SURREY COUNTY COUNCIL - RELEVANT REPRESENTATION SEPTEMBER 2019

M25 JUNCTION 10/A3 WISLEY INTERCHANGE

PINS Reference: - TR010030

Figure 3-1 Layout of south-facing slips at Ockham as proposed by RHS

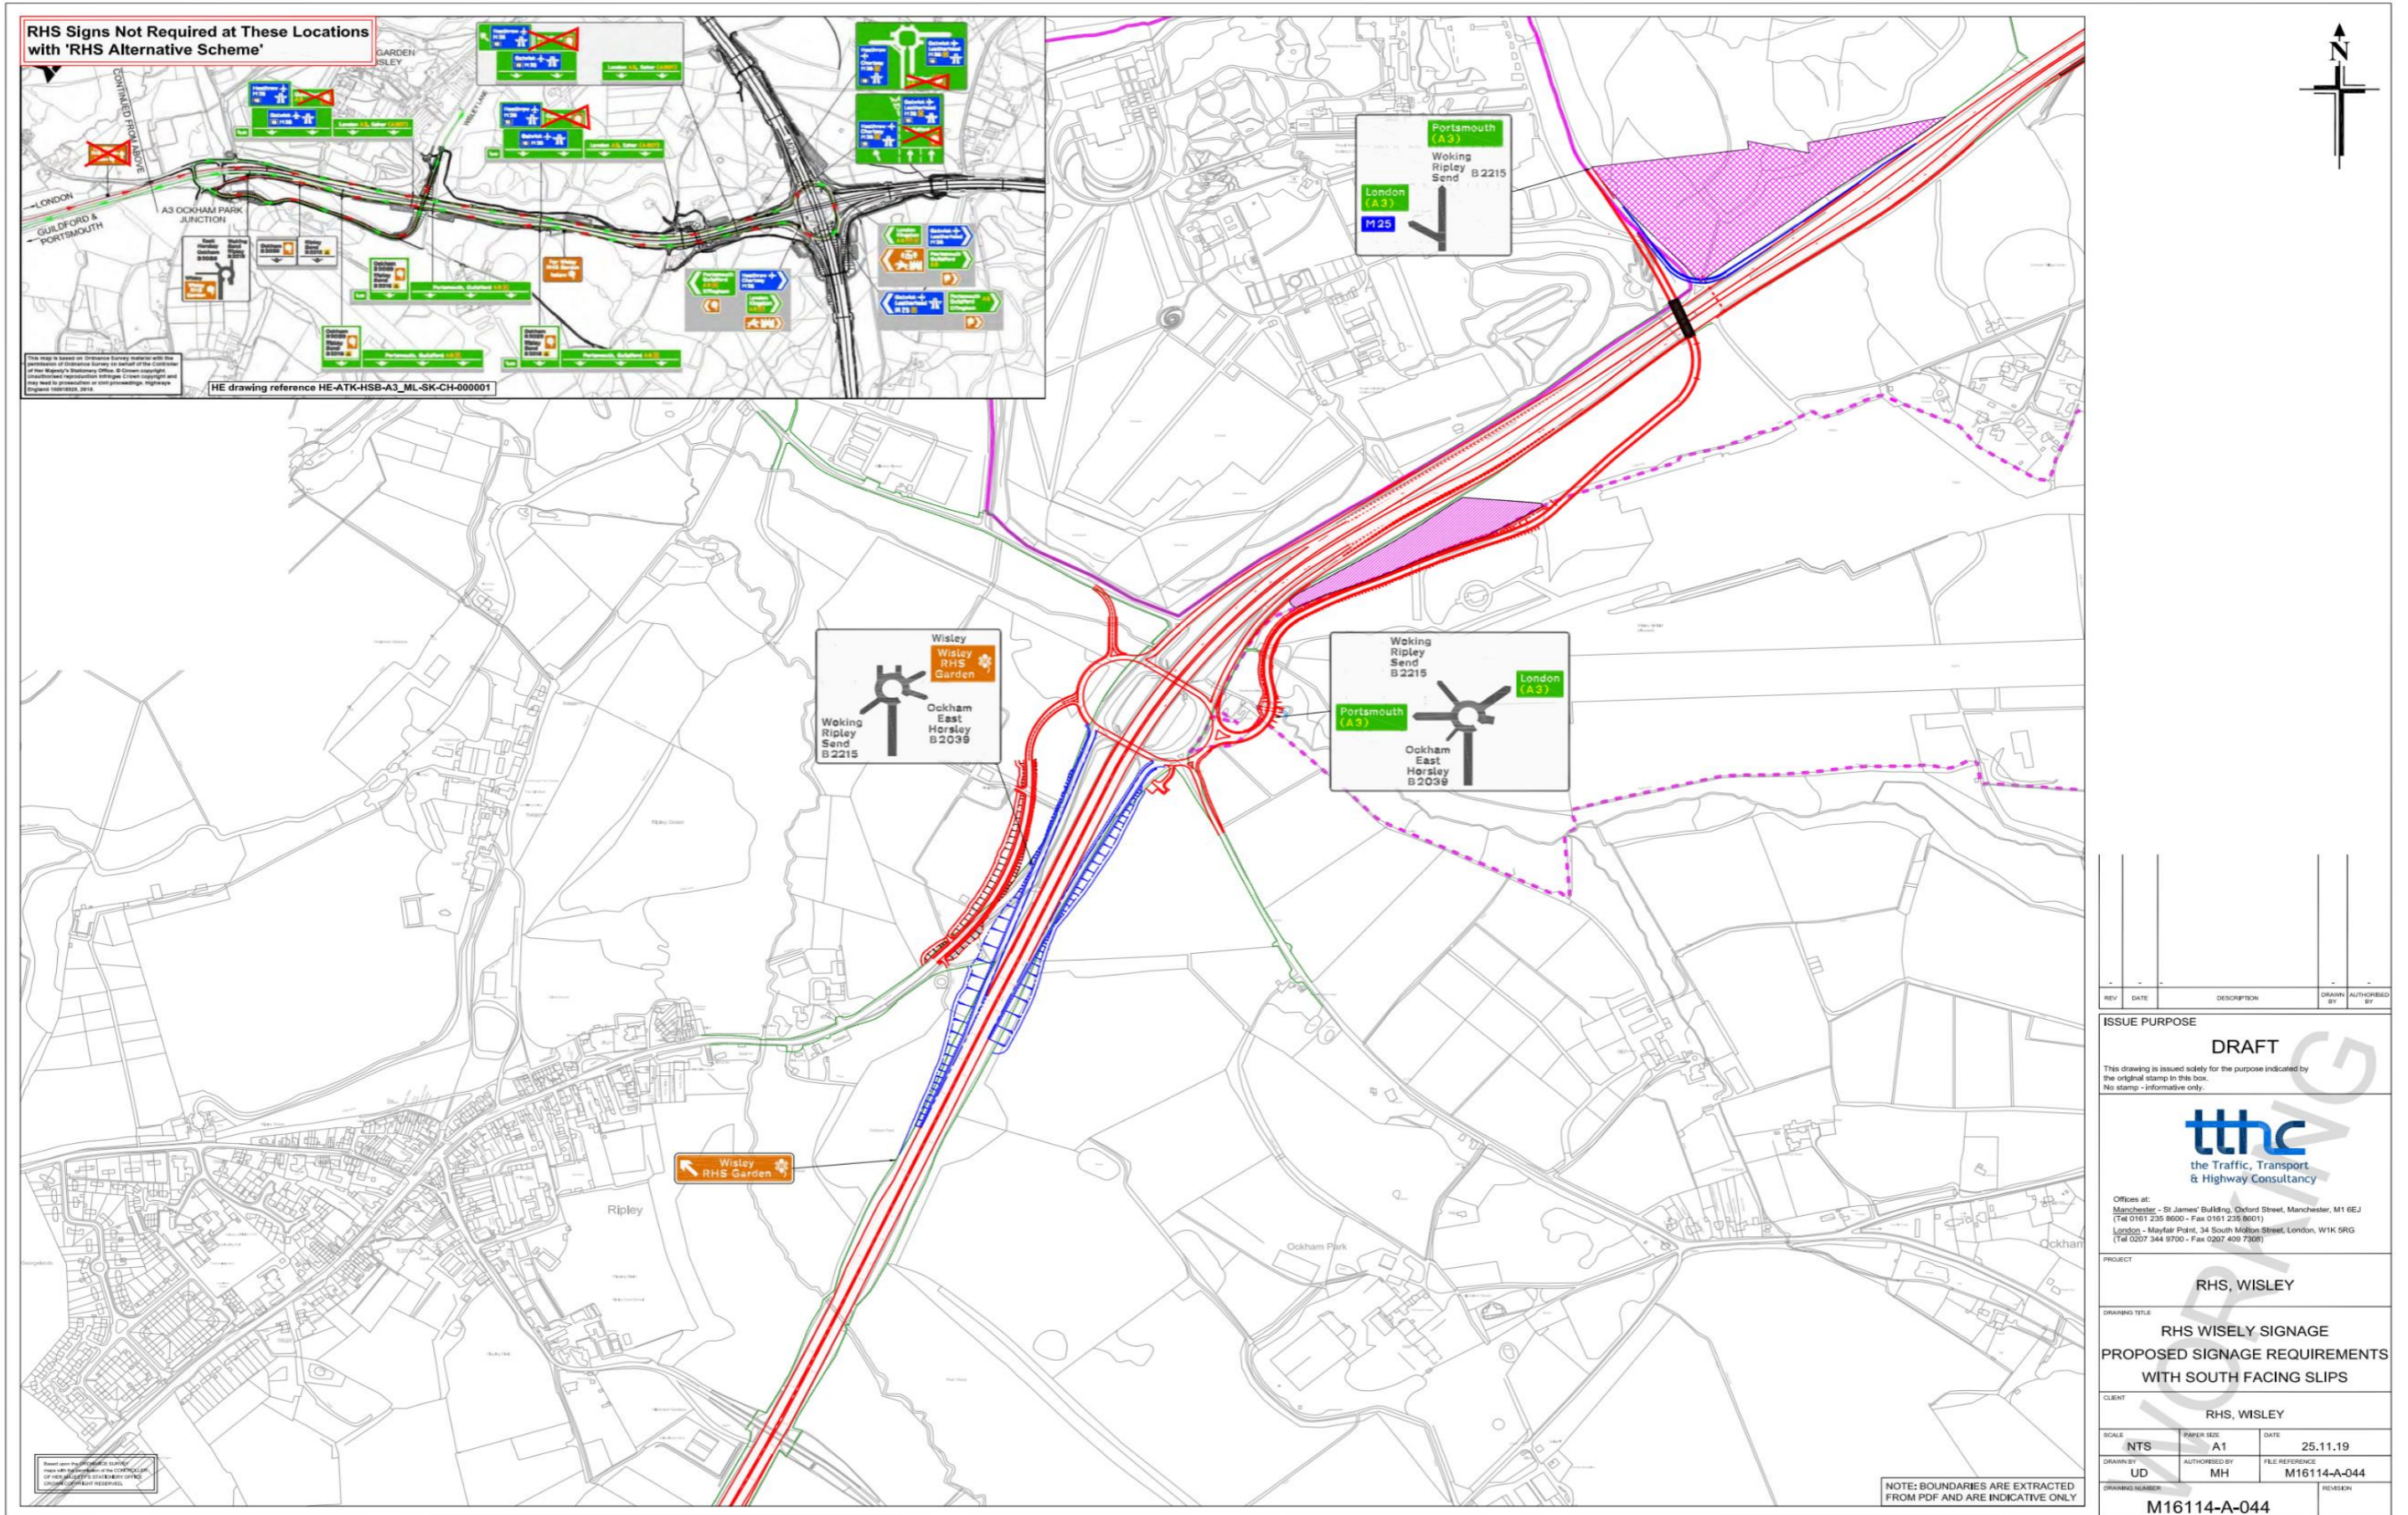
- 2.2.5 In respect of the potential impacts on the Local Road Network, in particular in and around Ripley, the County Council would ask that Highways England provide the modelling/evidence in respect of south facing slip roads at the Ockham Roundabout to demonstrate whether these would have a positive impact overall on the Local Road Network and not to the detriment of other communities served by the Local Road Network.

Highways England have previously stated that the proposed scheme does not require these slip roads and have made it clear that they will not provide south facing slip roads at Ockham Roundabout. Even though, however, it has been requested by the County Council, Highways England have not to date provided a detailed technical/feasibility assessment for each separate component below (including traffic, environmental and cost impacts at each location and on the surrounding communities) setting out the basis for their decision:

- (a) a northbound off slip at Ockham Roundabout
- (b) a southbound on slip at Ockham Roundabout
- (c) retaining a left turn out of Wisley Lane onto the A3
- (d) to assess (a) to (c) above with north facing slips at the Burntcommon junction (as proposed in the Guildford Local Plan)

- 2 As set out in para 2.2.5 the County Council would ask that Highways England provide the modelling/evidence in respect of south facing slip roads at the Ockham Roundabout to demonstrate whether these would have a positive impact overall on the Local Road Network and not to the detriment of other communities served by the Local Road Network.

The County Council recognise that this is not currently included in the DCO red line boundary or supporting DCO technical information; the County Council, however wish to understand if both or one of these slips roads e.g. the northbound off slip at Ockham Interchange could provide the required mitigation to the impacts on the Local Road Network including Ripley.
